SECTION 4.55(1A) MODIFICATION APPLICATION (MOD 4) WAGGA WAGGA BASE HOSPITAL, CORNER OF EDWARD AND DOCKER STREET, WAGGA WAGGA

This application has been prepared by Ethos Urban on behalf of NSW Health Infrastructure, pursuant to Section 4.55(1A) of the *Environmental Planning and Assessment Act 1979* (EP&A Act) to modify Development Consent SSD 9033 relating to the Stage 3 Redevelopment of the Wagga Wagga Rural Referral Hospital, located on the corner of Edward Street and Docker Street, Wagga Wagga (the site).

The modification involves amendments to the design related to the relocation of the on-site generator. This application identifies the consent, describes the proposed modifications and provides an assessment of the relevant matters contained in Section 4.55(1A) of the EP&A Act. This application is accompanied by:

ARCHITECTURAL SERVICES
SITE PLAN - PROPOSED
GENERATOR RE LOCATION

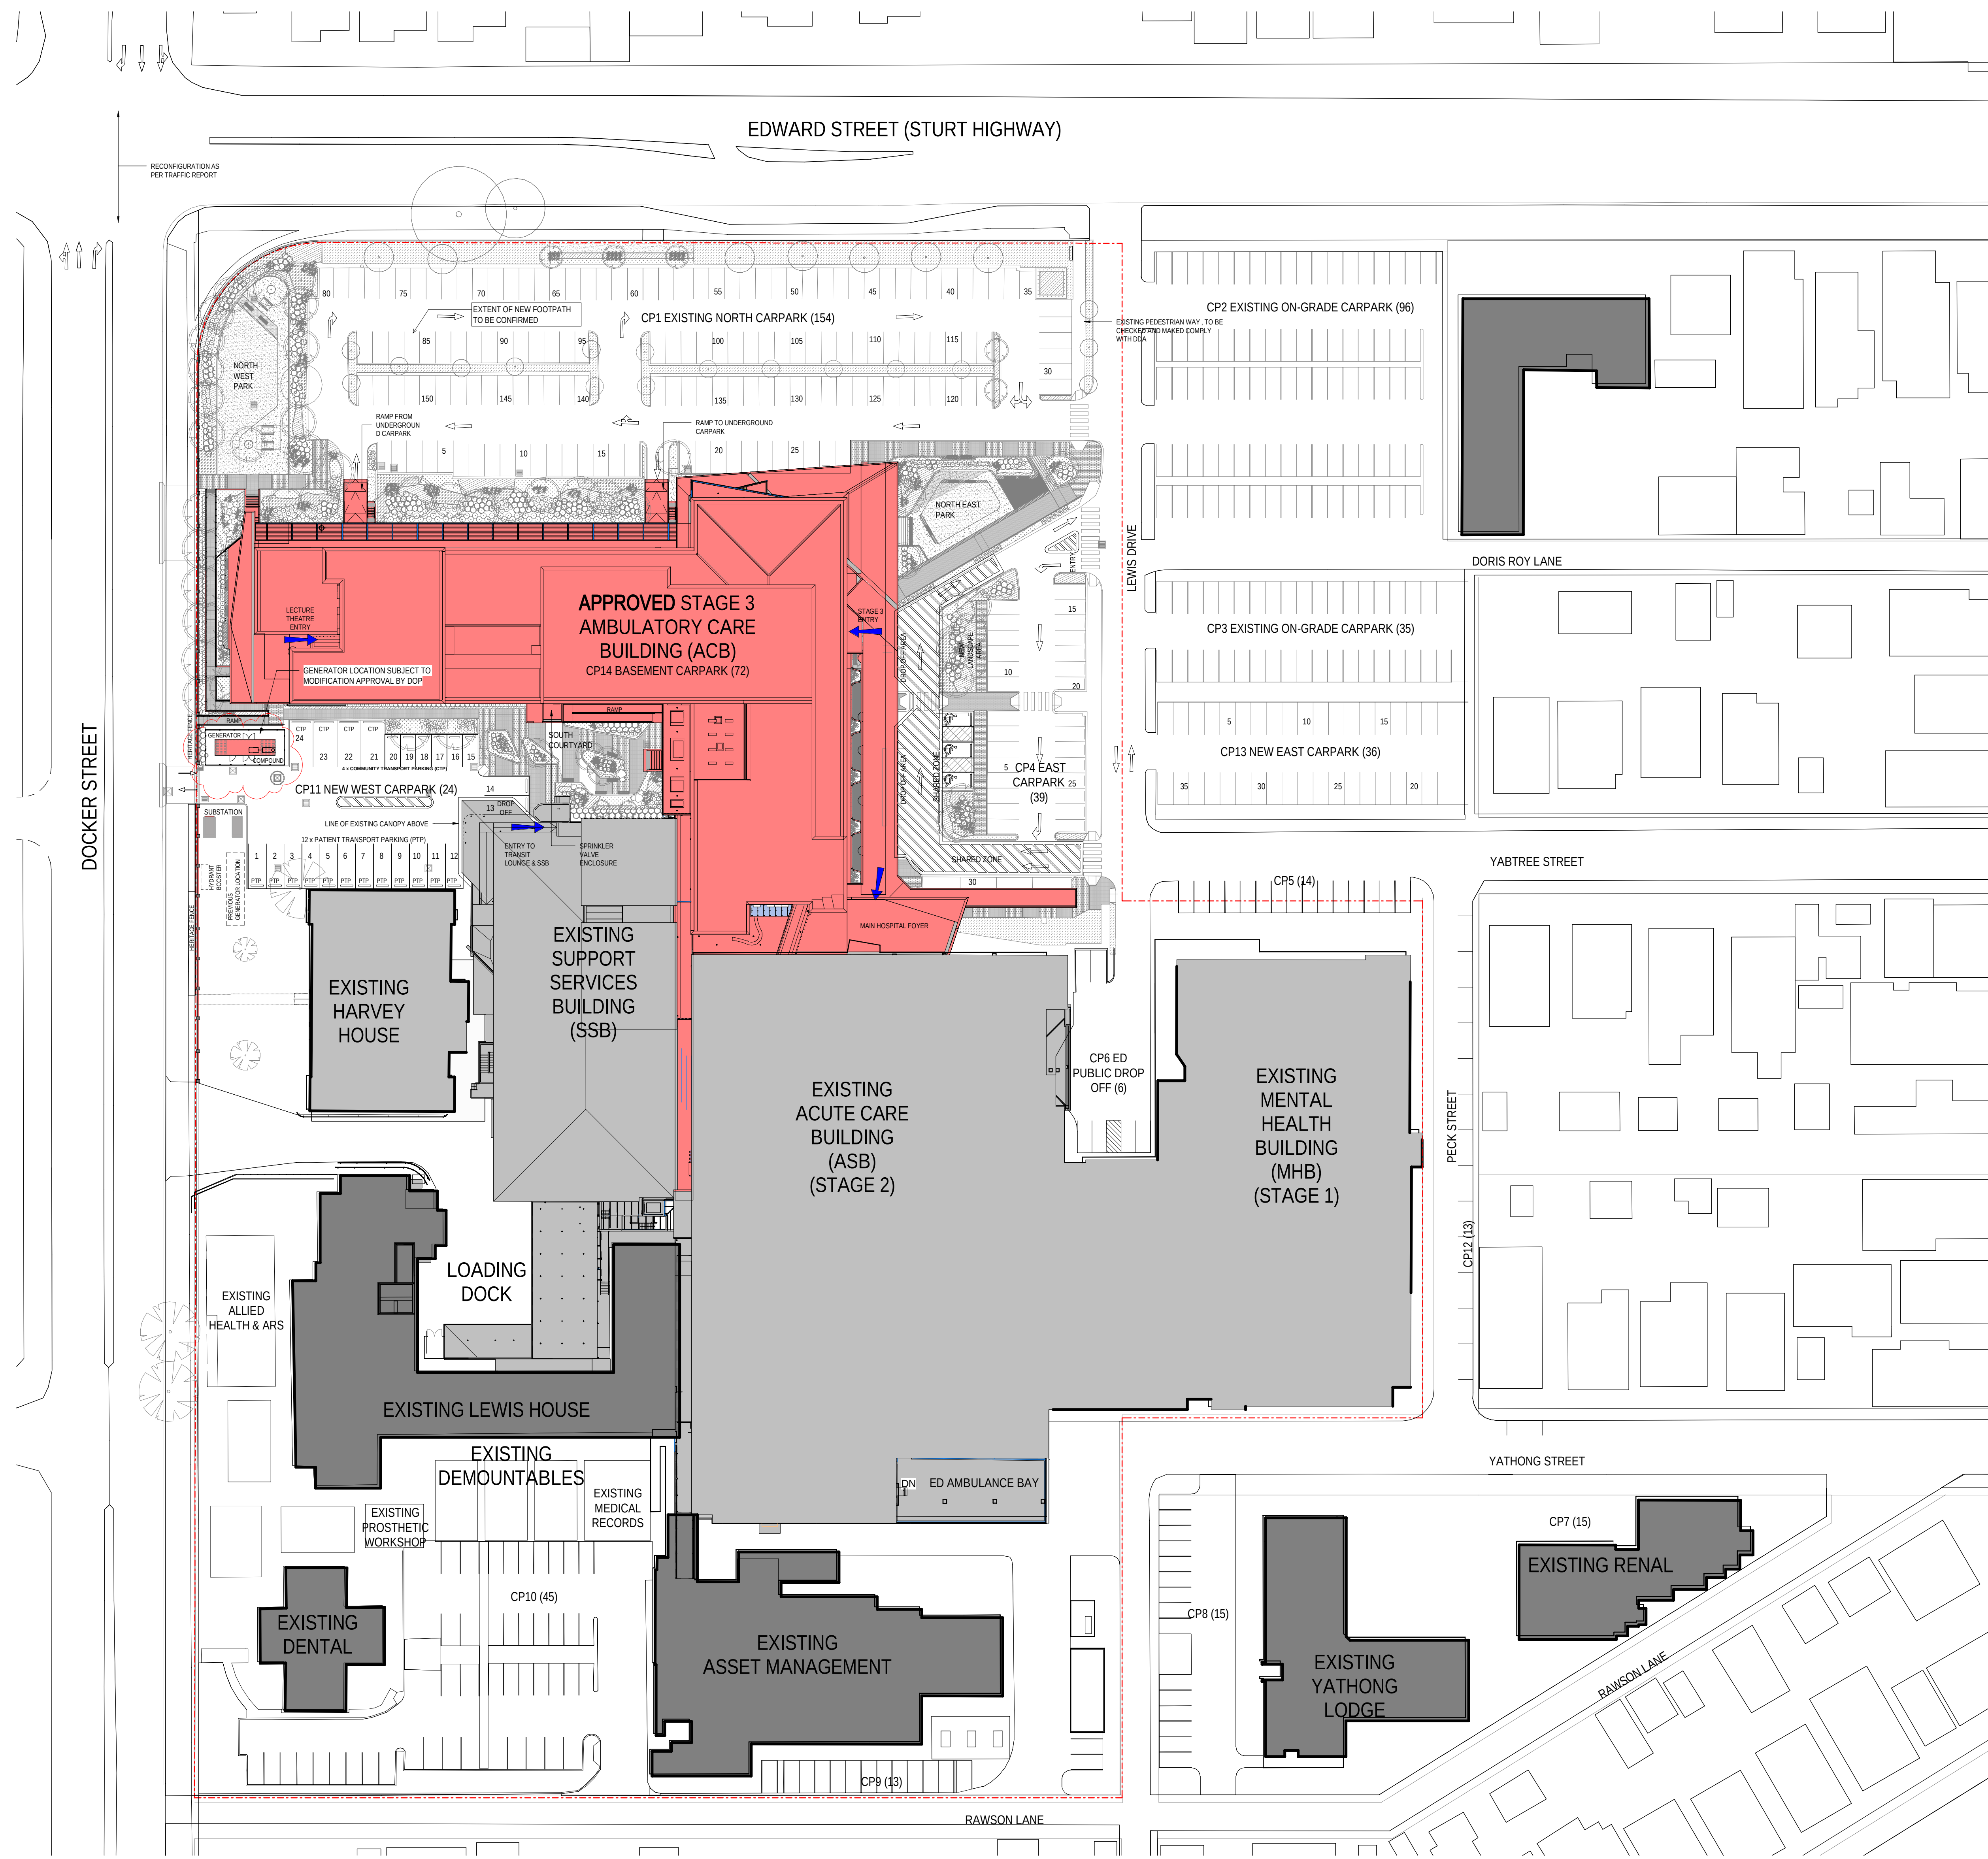
The proposed modification involves an amendment to the location of the on-site generator from in front of Harvey House, to a more appropriate location adjacent to Docker Street and the approved Stage 3 extension. The modification will also reduce the number of generators from two to one. The currently approved location of the generators will remain a grassed space as currently exists.

The relocation of the generator will result in a loss of three car parking spaces (see further discussion at **Section 4.3.1**). The overall parking requirement within WWBH will be maintained.

It will also require a concrete and colorbond enclosure, set back from the Docker St boundary, to allow continuation of the landscape border proposed for the project.

The proposed modification to the location of the generator is detailed in the amended Site Plan prepared by Jacobs (**Attachment A**) and extracted below in **Figure 1**. A new Plan showing the elevation and section view is also provided (see **Figure 2** and **Figure 3**).

TITLE
ARCHITECTURAL SERVICES
GENERATOR ELEVATIONS

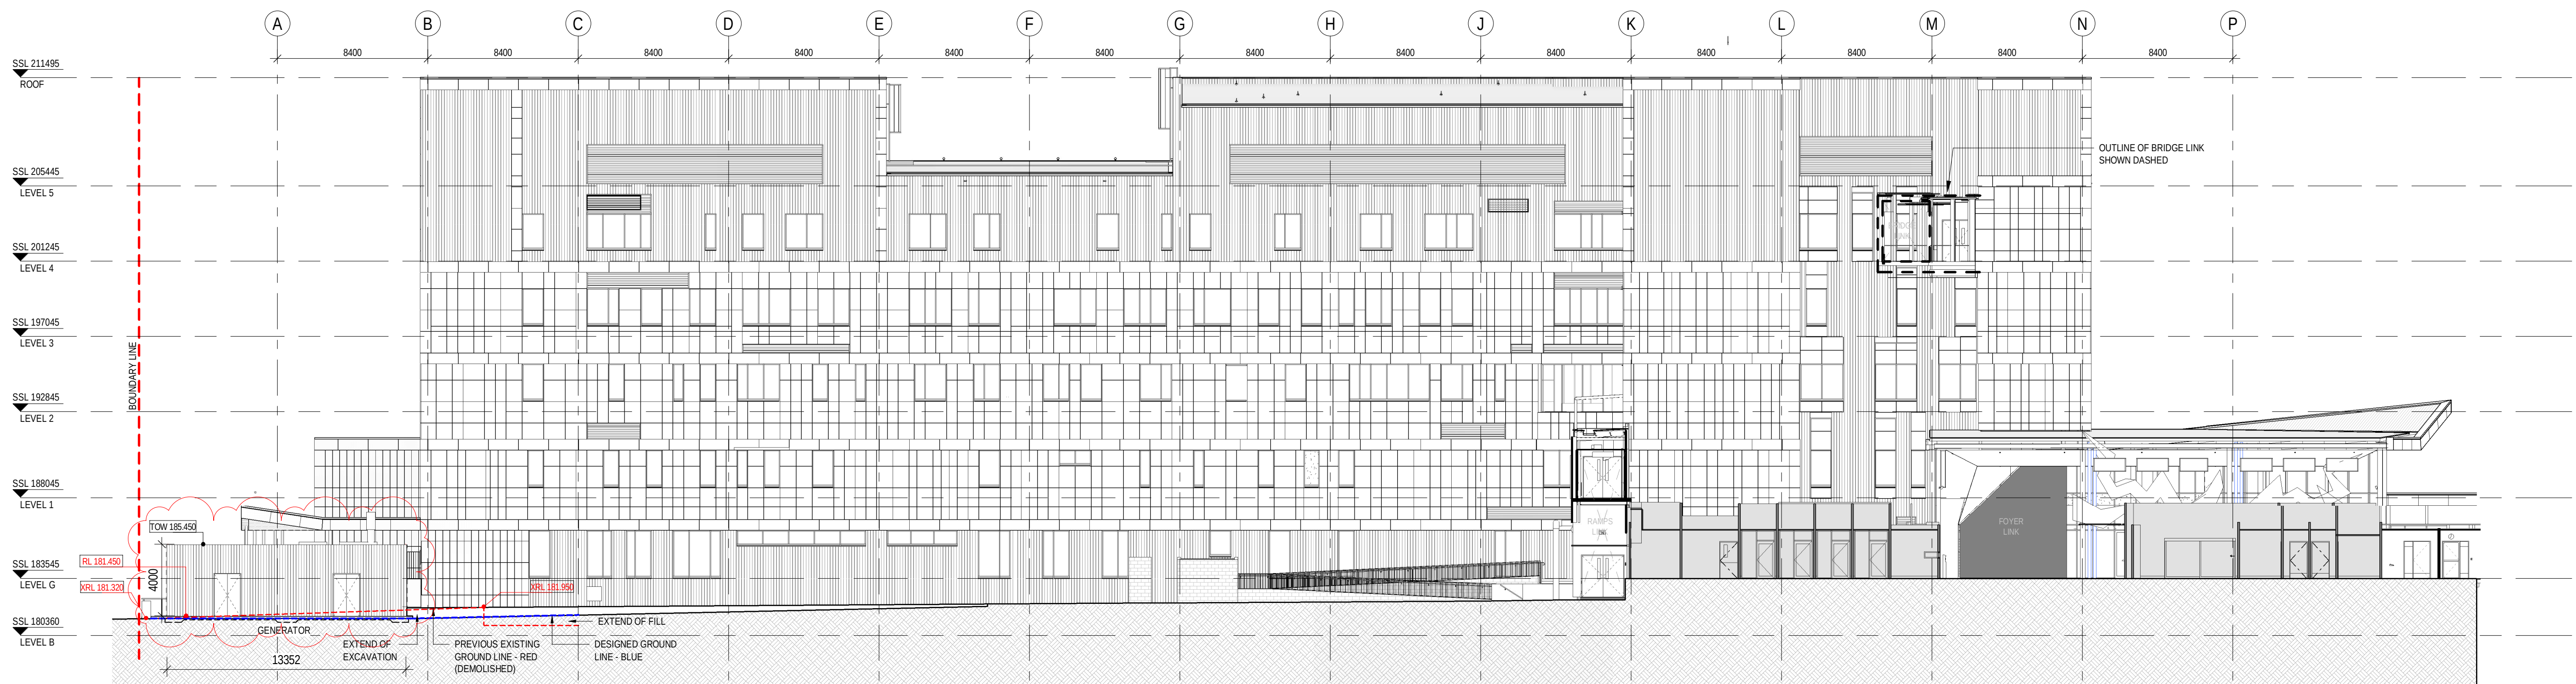
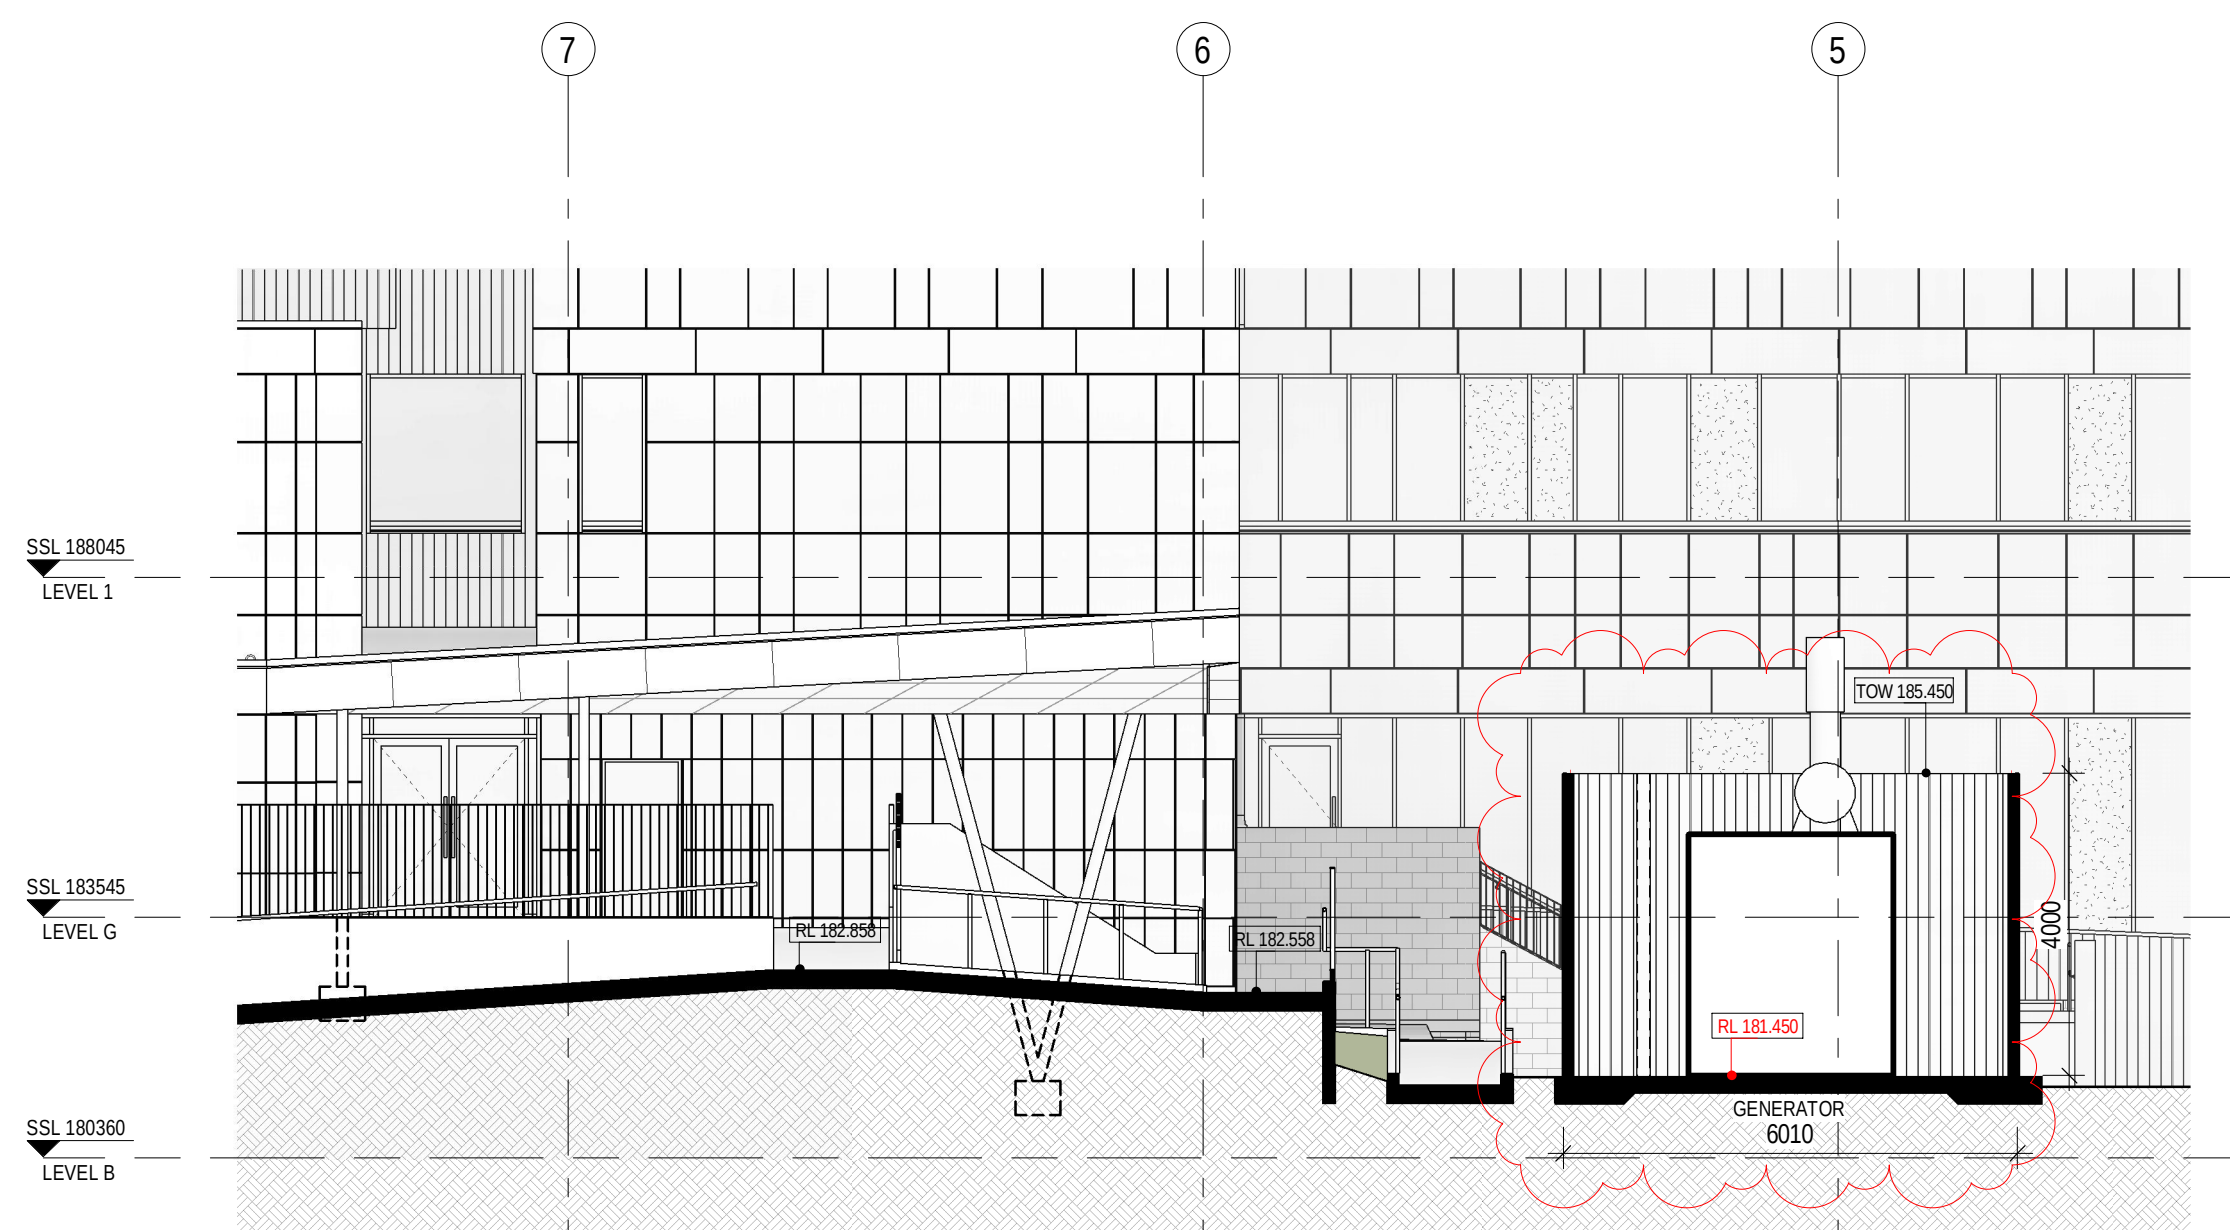
A new concrete and colourbond enclosure will be required to facilitate the new generator. The enclosure is open to the sky and is a requirement for all Generators. The enclosure is set back from the Docker St boundary, retaining a landscaped border.

There is a gradual slope in the existing topography requiring a minor cut and fill of approximately 600mm over a distance of 14m. The generator enclosure will be viewed as approx. 3.4m in height from the north side and at 4m in height from the car park to the south side. This grading of the land is minor and will have negligible impact beyond that already assessed and approved by the original SSD DA.
